State of Washington
DEPARTMENT OF FISH AND WILDLIFE
South Central Region • Region 3 • 1300 W. University Way, Ellensburg WA 98926
Telephone: (509) 575-2740 • Fax: (509) 575-2474

RE: WDFW Comments on CU-23-00001 3 BR Custom Cuts

Thank you for the opportunity to comment on the 3 BR Custom Cuts project (CU-23-0001). The Washington Department of Fish and Wildlife (WDFW) has reviewed the SEPA Checklist and supporting documents.

Drawing file: CU-23-00001 3 BR Custom Cuts / CU-23-00001 3 BR Custom Cuts Site Plan.pdf

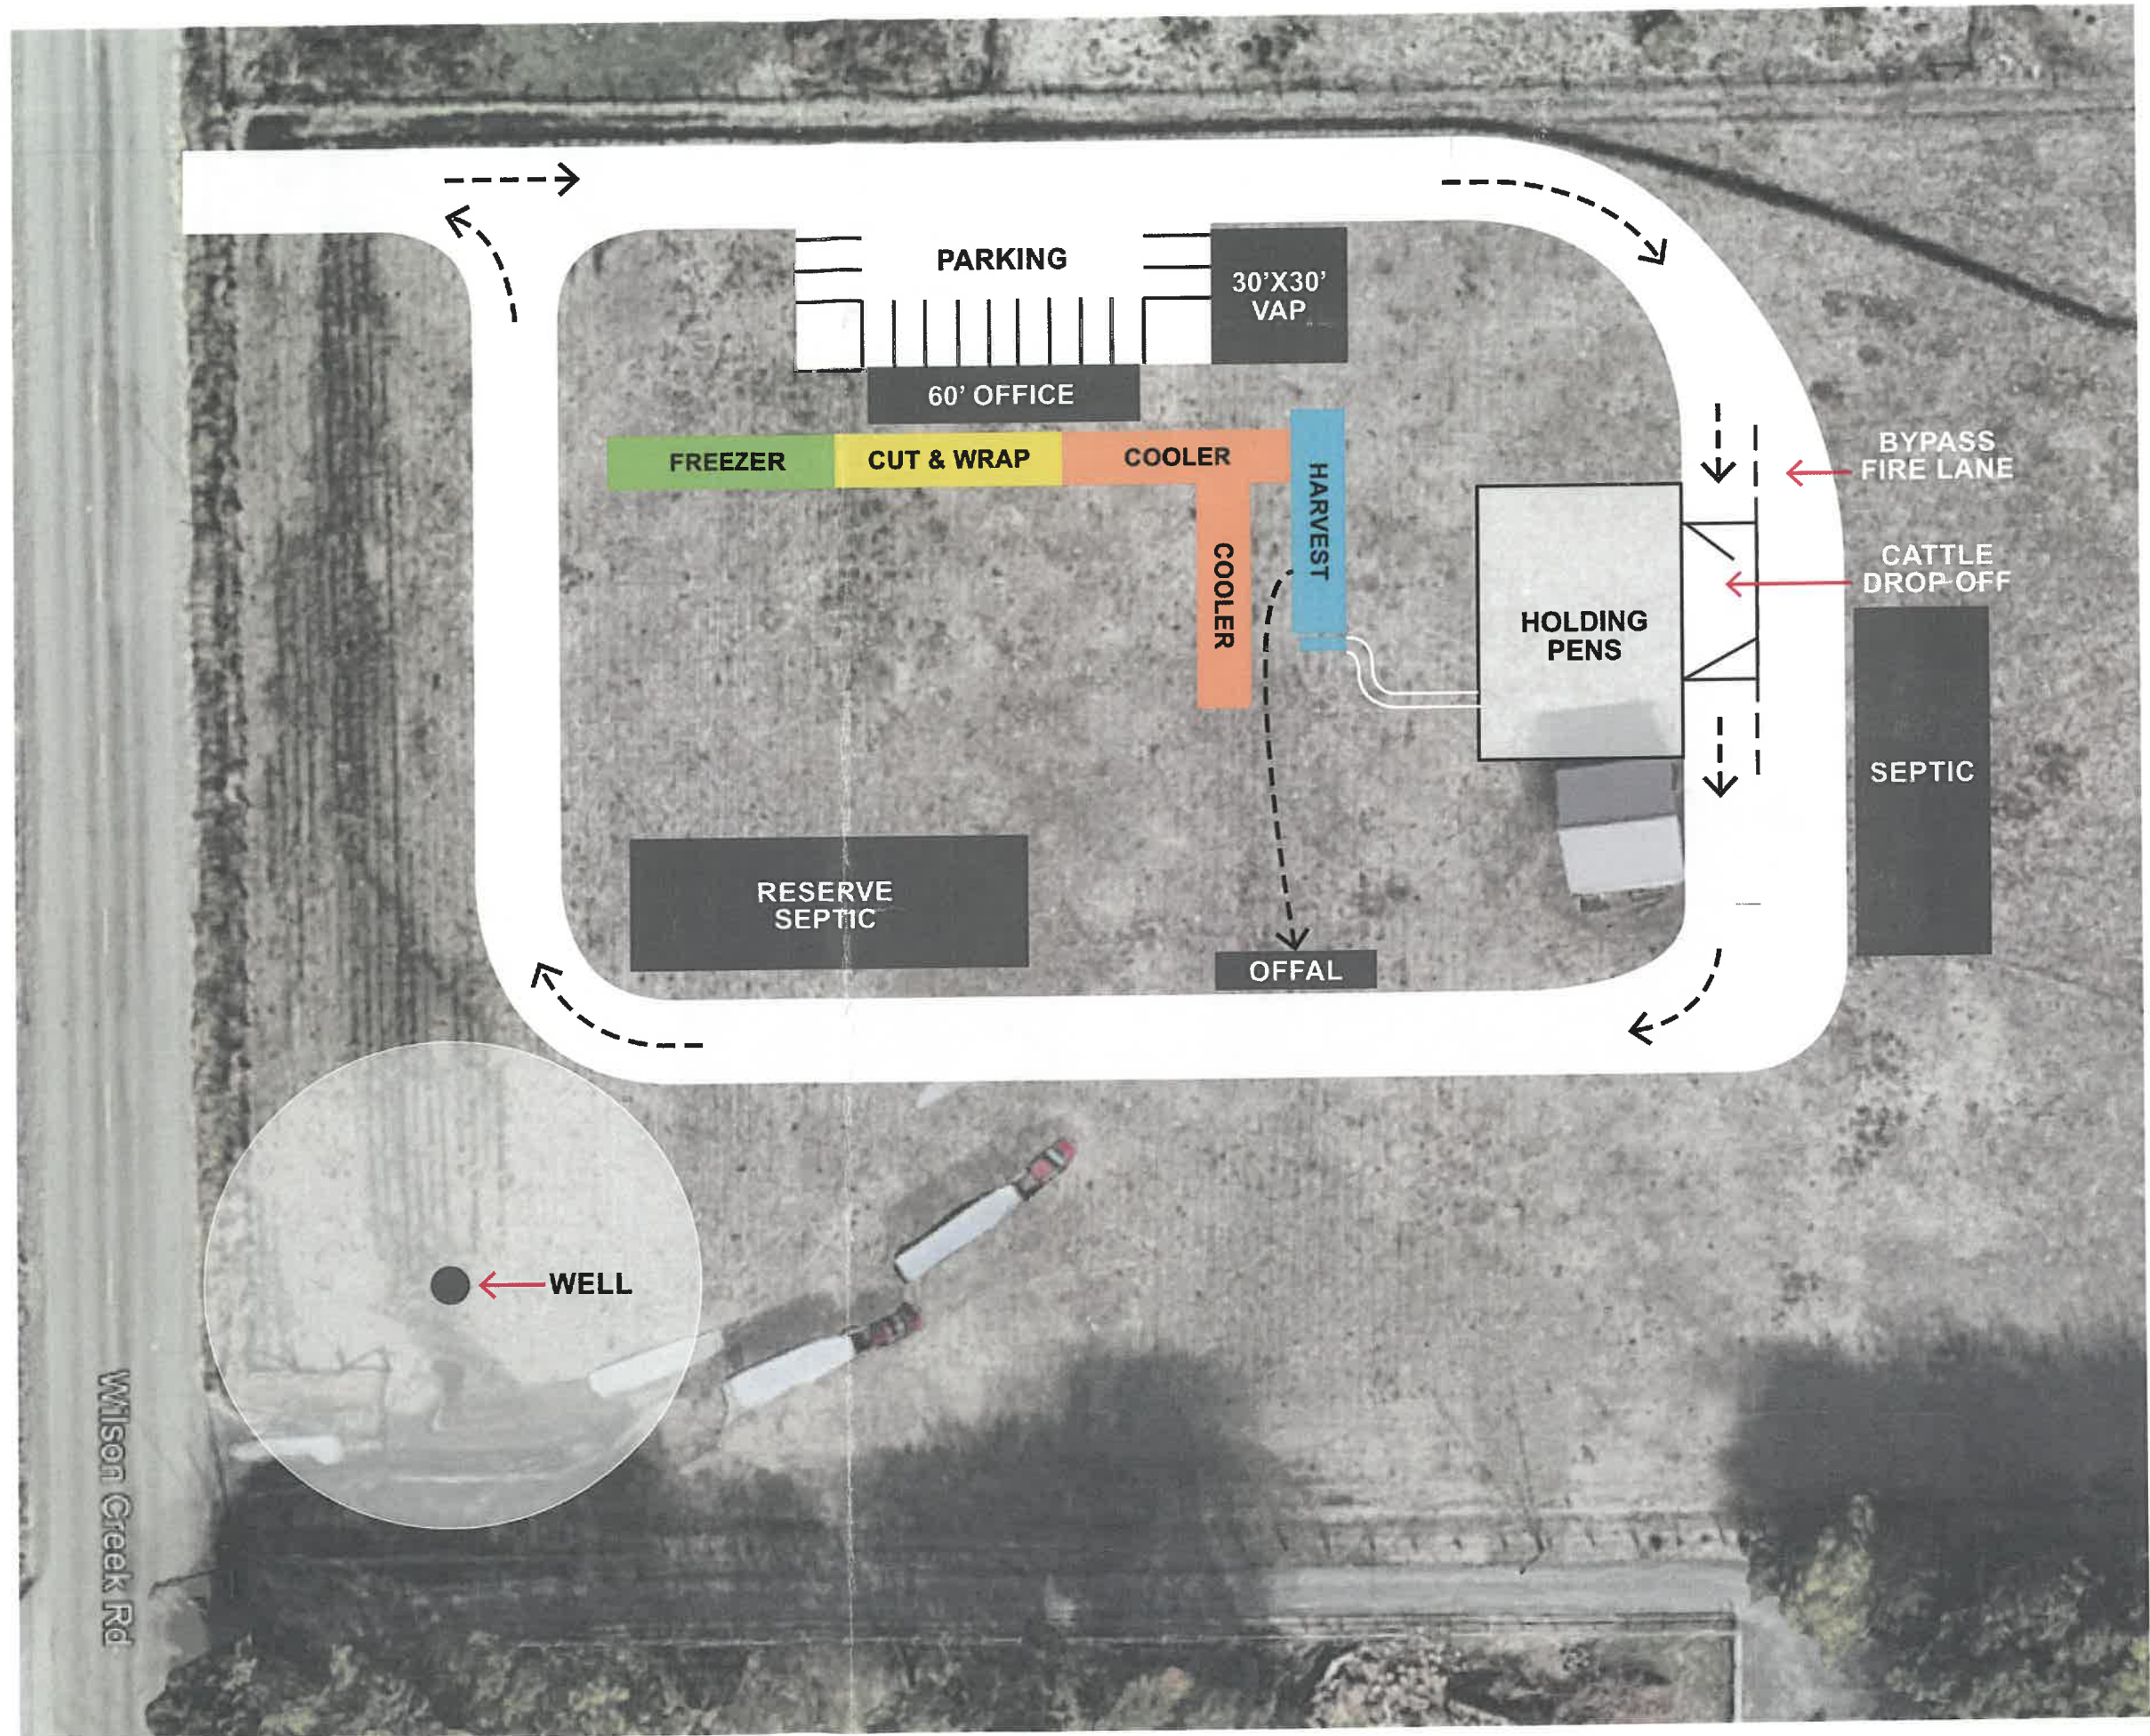
WDFW has questions as to how carcasses will be disposed of after processing. We note that there is an “offal” location shown on the site plan, but could find no further information about this aspect of the proposed development within the application materials.

WDFW recommends that 3 BR Custom Cuts develops a carcass/offal management plan before beginning operations. With an appropriate carcass management plan in place, the processing plant will reduce the chances of attracting wildlife, such as predators and scavengers, onto the property. WDFW requests the ability to review and comment on the management plan before finalization, to ensure that the plan appropriately addresses wildlife management concerns and is successful at minimizing human-wildlife conflict.
